Subject: RE: CM/52/21/DOC

Proposal: Approval of details reserved by condition imposed under CM/16/21/PL relating to conditions 6-details of proposed grease trap/separator, 7-extraction details & 8-boundary treatments to southern & western boundary.

Address: Bairds Farm Shop, Crookthorn Lane, Climping, Littlehampton, West Sussex, BN17 5SN

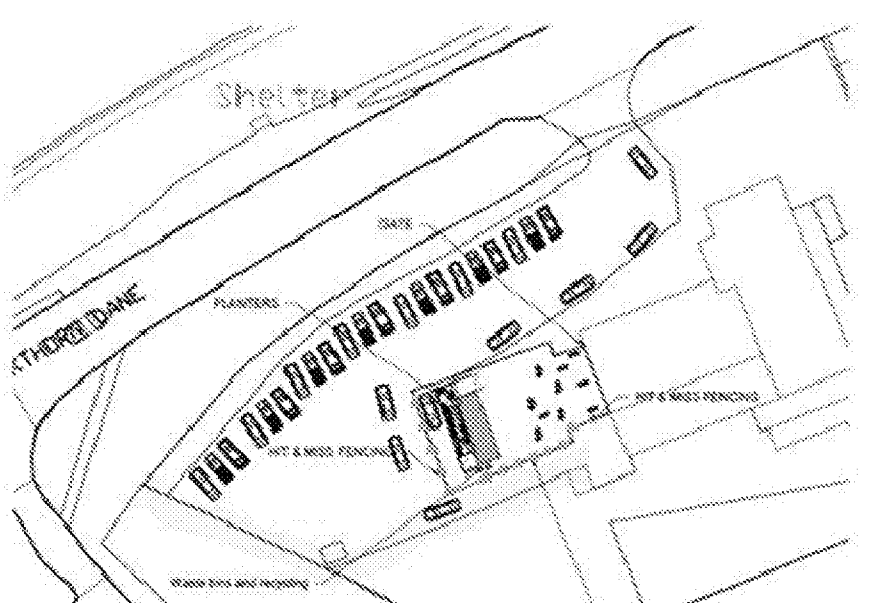
Your application shows the fencing already erected by the landowner along the western boundary which is fine. You then show a line of laurel plants along the southern boundary. There needs to be a similar style close-boarded fence along this line but you could retain the laurel plants in front of it if you wish.

Therefore what we require is an annotated block plan (suggest you annotate the approved one from the application) which indicates existing fencing along the highlighted western boundary and indicates new fencing along the highlighted southern boundary. You will need to highlight the respective boundaries like I have done (albeit more accurately) and add text to say what each of the two boundaries is. Then we will need a fencing specification for the southern boundary so we know exactly what we are approving.
